From: Amanda Scholes on behalf of Planning.Responses
Sent: 12 November 2020 08:47
To: Planning Scanning
Subject: FW: Planning Consultation on: BN/123/20/TC

Prior Notification of Work to Tree(s) in a Conservation Area

Application No: BN/123/20/TC
Registered: 22nd October 2020
Site Address: Flint House Church Lane Eastergate PO20 3UR
Grid Reference: 494357 105524
Description of Works: Various works to various trees within the Eastergate Square Conservation area.

Hand-drawn
Site Plan

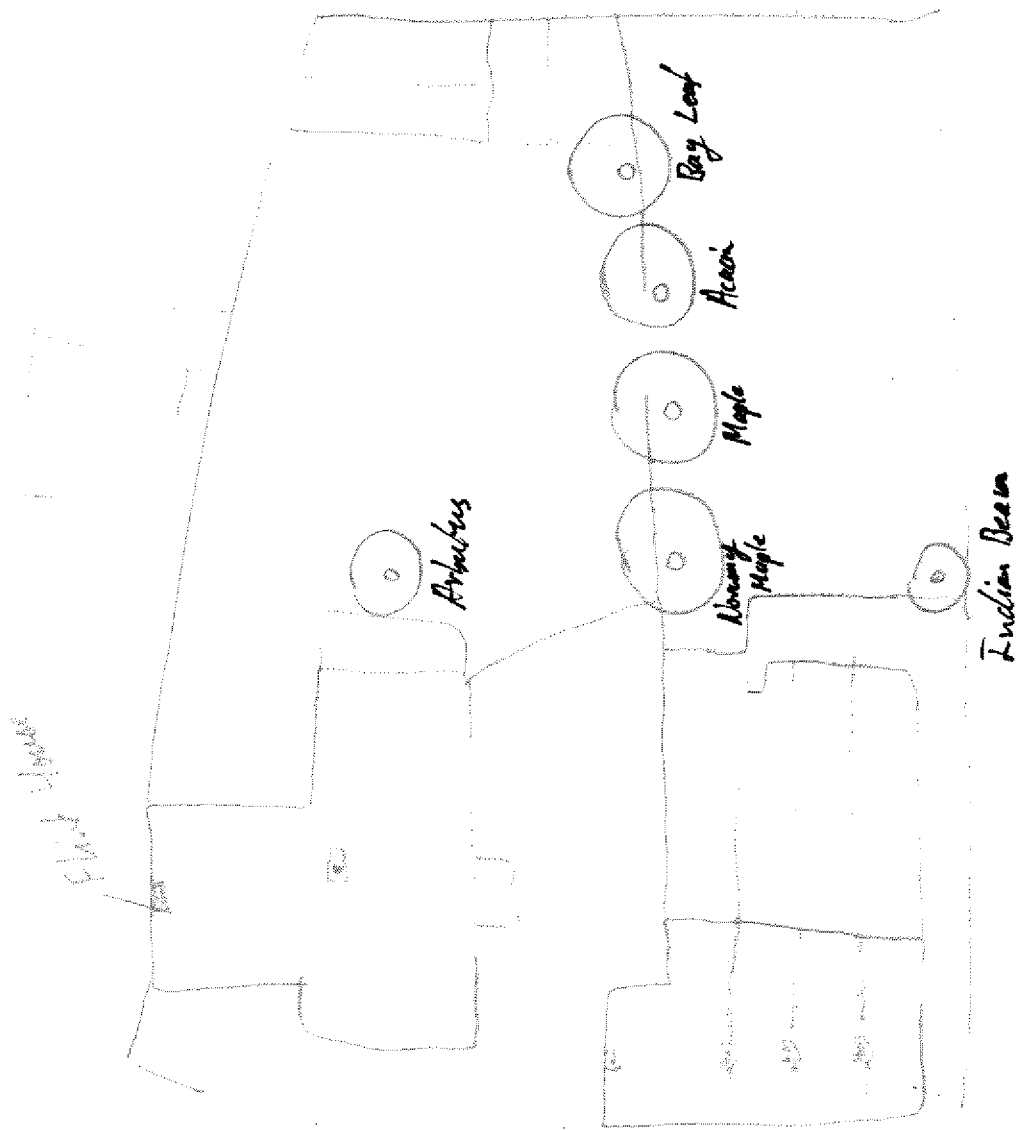
At a meeting of the Barnham and Eastergate Parish Council's Planning & Environment Committee held on 27th October the Committee resolved to raise no objection to this application subject to the ADC Tree Officer having no issues with the proposal. However, they did comment that they the proposed reduction of 25% was excessive.
